CITY OF ALBUQUERQUE

July 19, 2017

RE: 2609 Corianda Court NW
Grading and Drainage Plan
Stamp Date: 7/11/17
Hydrology File: G13D026

Based upon the information provided in your submittal received 7/12/2017, the Grading Plan **is not** approved for Building Permit. The following comments need to be addressed for approval of the above referenced project:

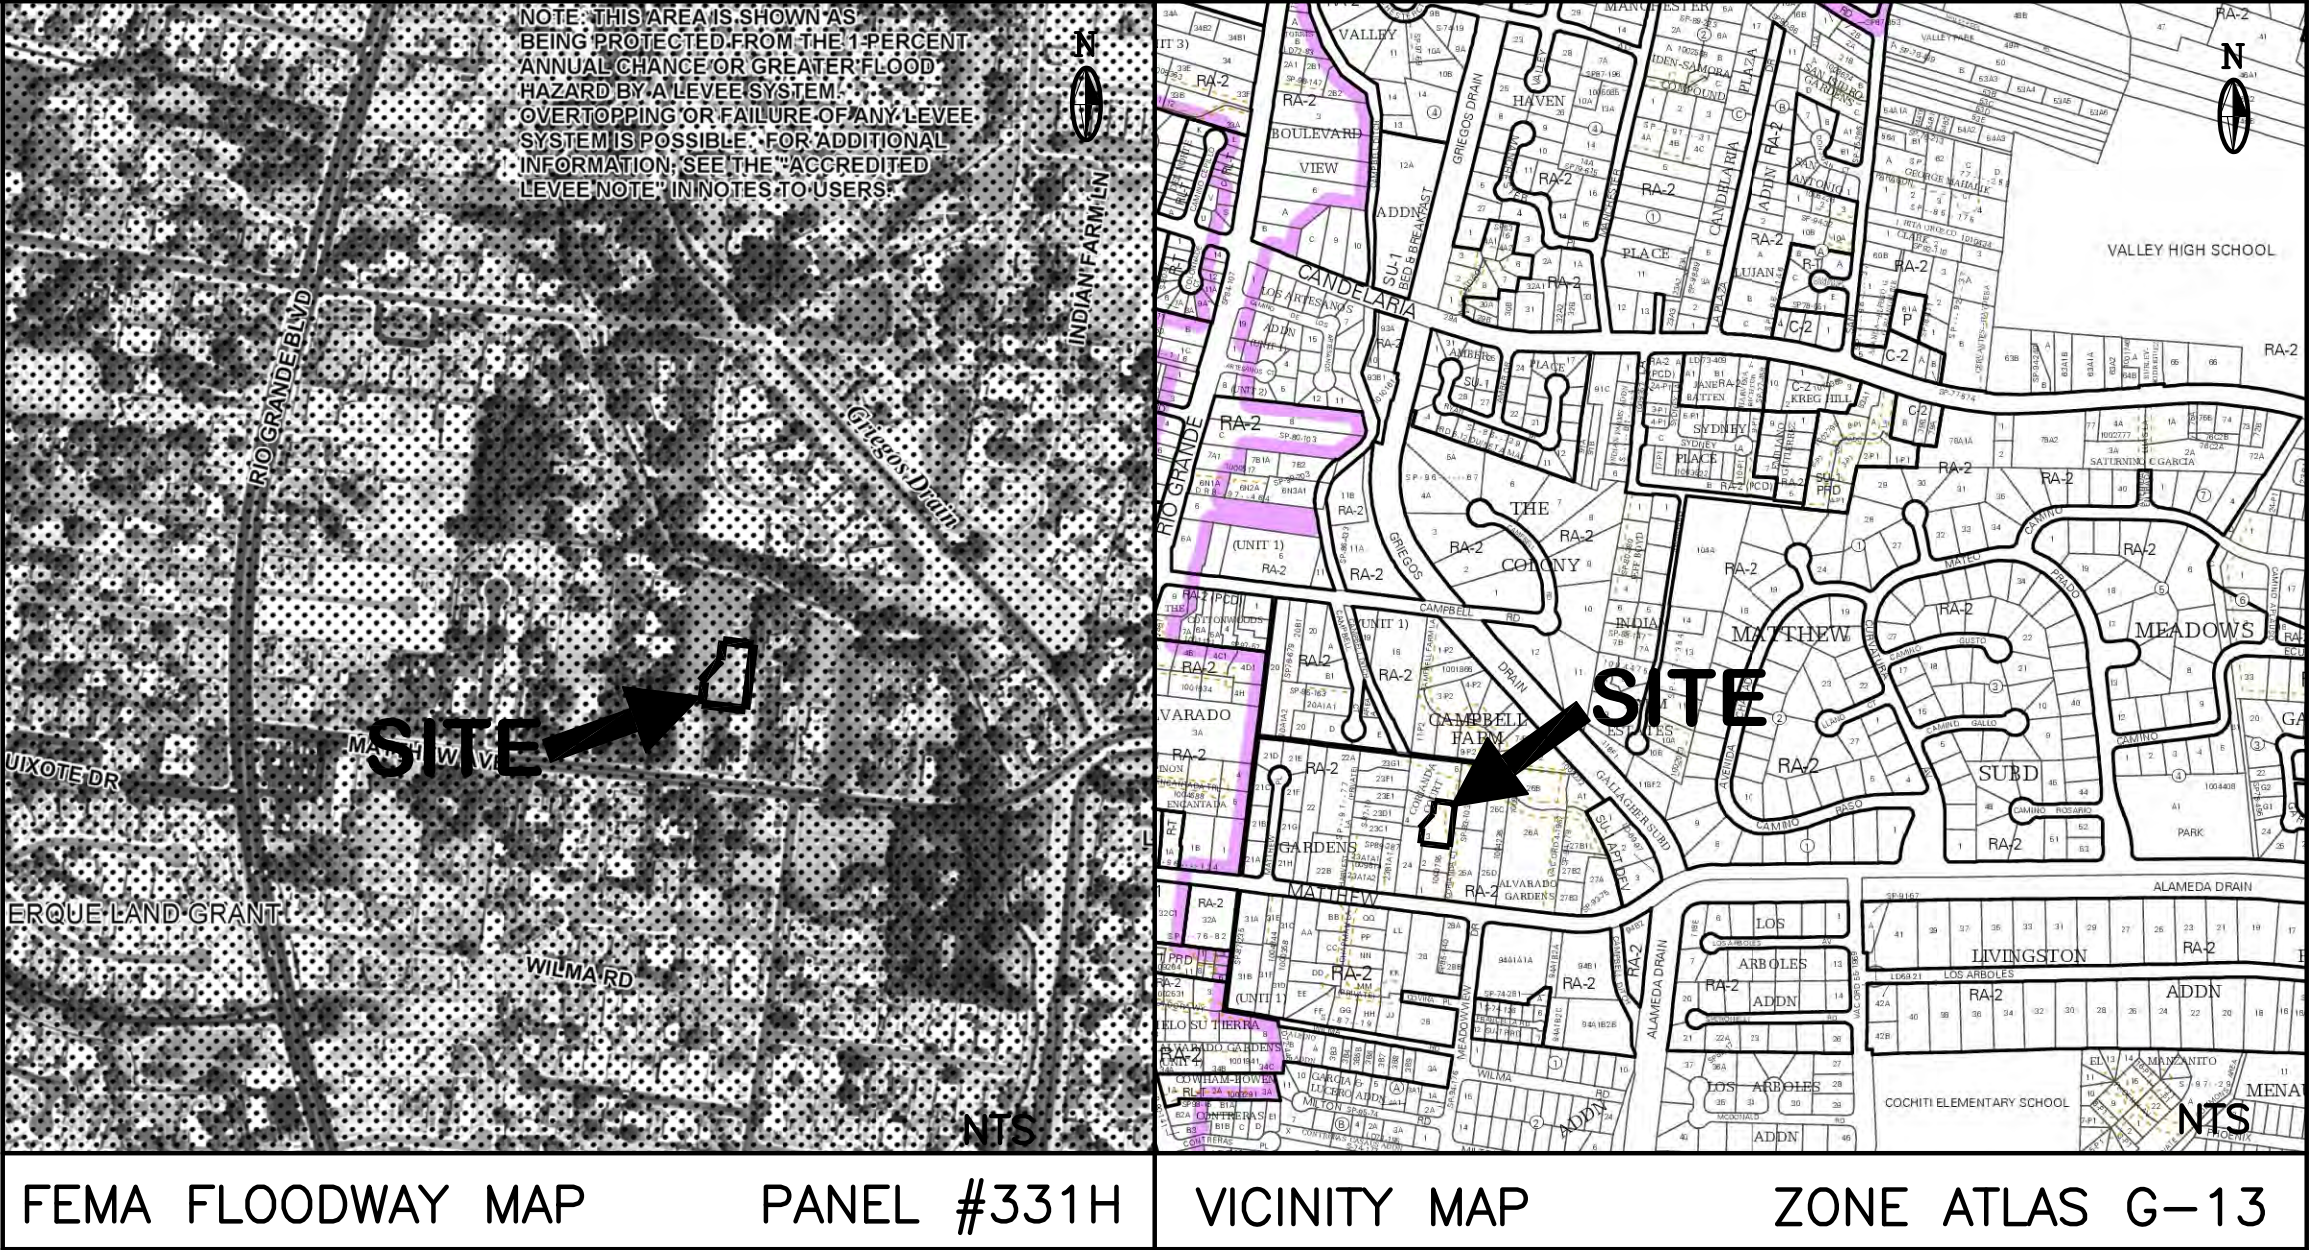
1. Please provide the flood plain note with effective date. This property is in Zone "X" protected by levee.
2. The approved Grading and Drainage for the subdivision had the lots in a "flat grading scheme". The Zone X Protected by Levee / Flat Scheme is as follows:
 - a. The floor elevation of the house must be a minimum of 1' above the highest existing adjacent elevation.
 - b. A retention pond is required. Required Volume = 3.67" x proposed impervious area / (12in/ft). Show location and elevation of pond on plan. Show calculation of both required and actual volume.
 - c. The street must be allowed to drain into the lot.
3. Please provide either a CMU block garden wall or a berm along the property lines it ensure that the drainage stay within the lot.
4. As a reminder, please do not forget to create a pond across the private drive at the northeast portion of the property.
